Your ref:  
Our ref: 23/01908/F  
Please ask for: Miss Joanne Wren  
Direct dial: 01553 616233  
E-mail: borough.planning@west-norfolk.gov.uk

2 November 2023

Details: **Installation of 130kWp solar PV ground array for generation and consumption of electricity at the farm at Park Farm Castle Road Wormegay KINGS LYNN Norfolk**

Drawing Title  
**THARROS FARM ELEVATION DRAWING**

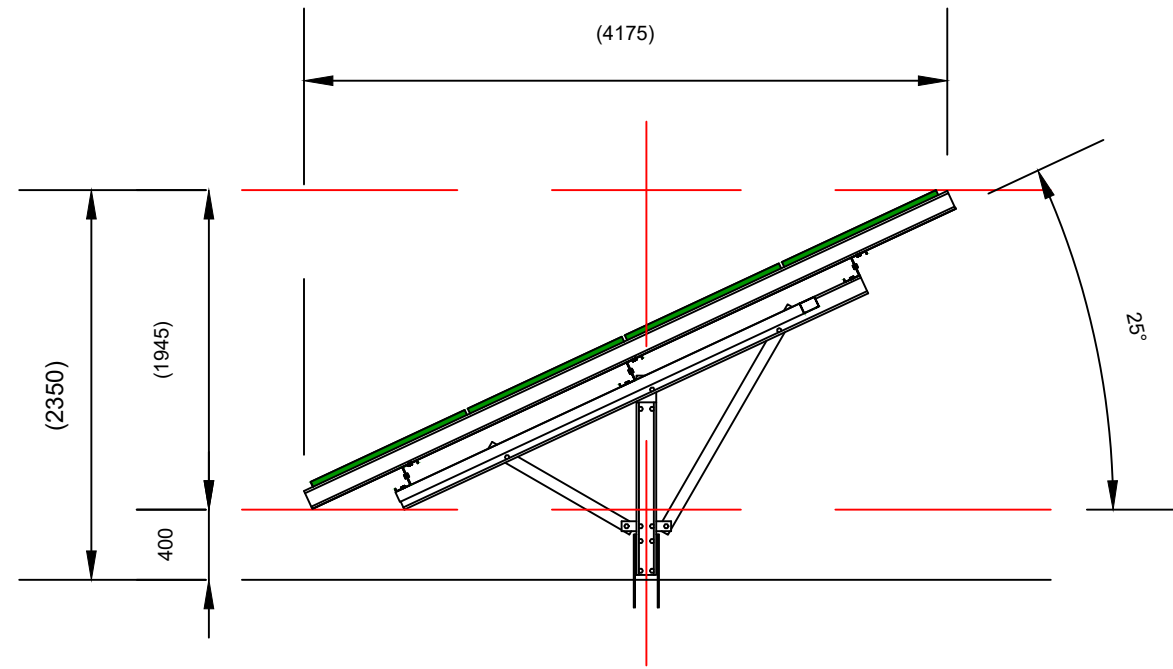
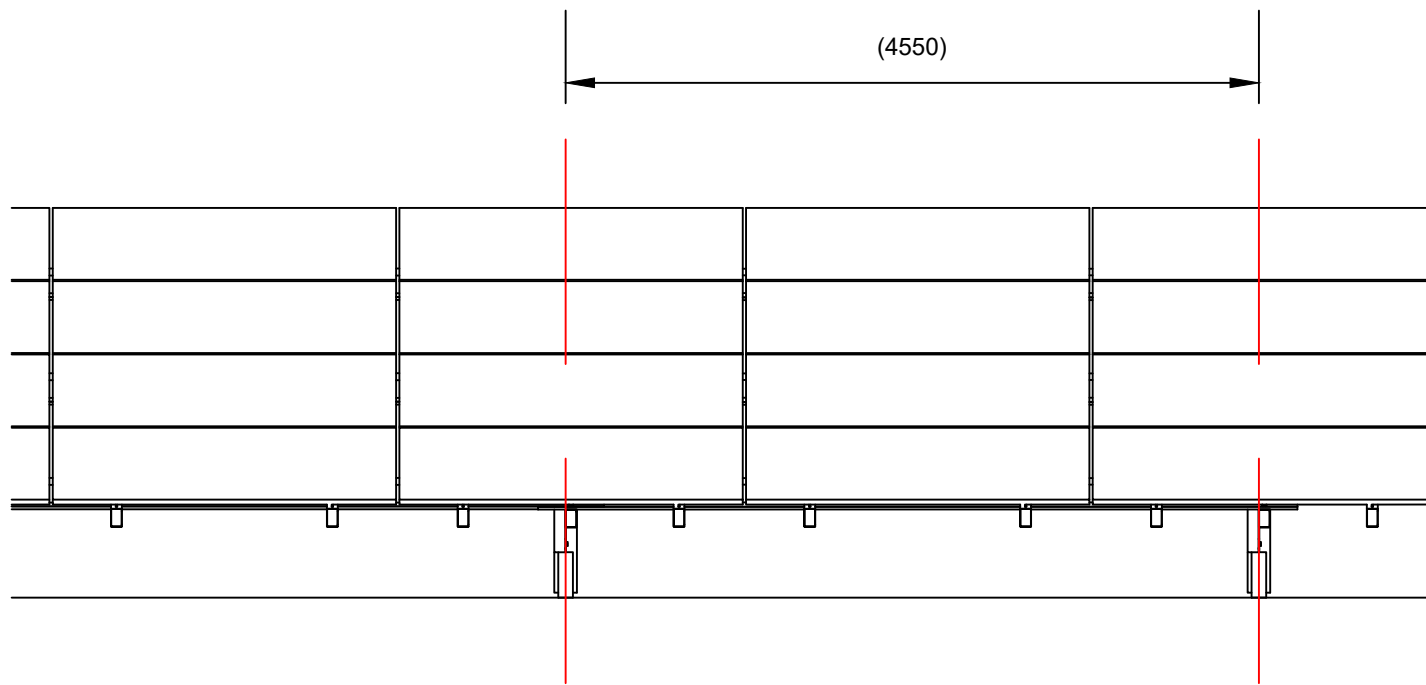
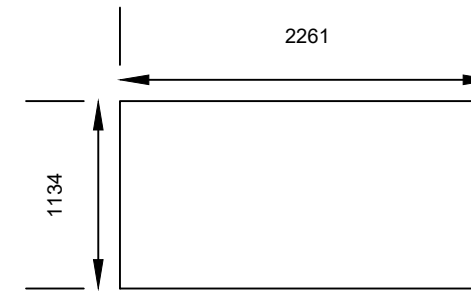
1. A Flood Risk Assessment is required to be submitted with this application, as the site lies within an area at risk of flooding.
2. The annotation on the drawing(s) submitted with your application refers to the drawing being not to scale. Please remove any such reference for the purposes of the planning application.
3. Thank you for your payment of £462 but the fee for this application is £1848. The fee is calculated at £462 for each 0.1 hectare or part thereof.
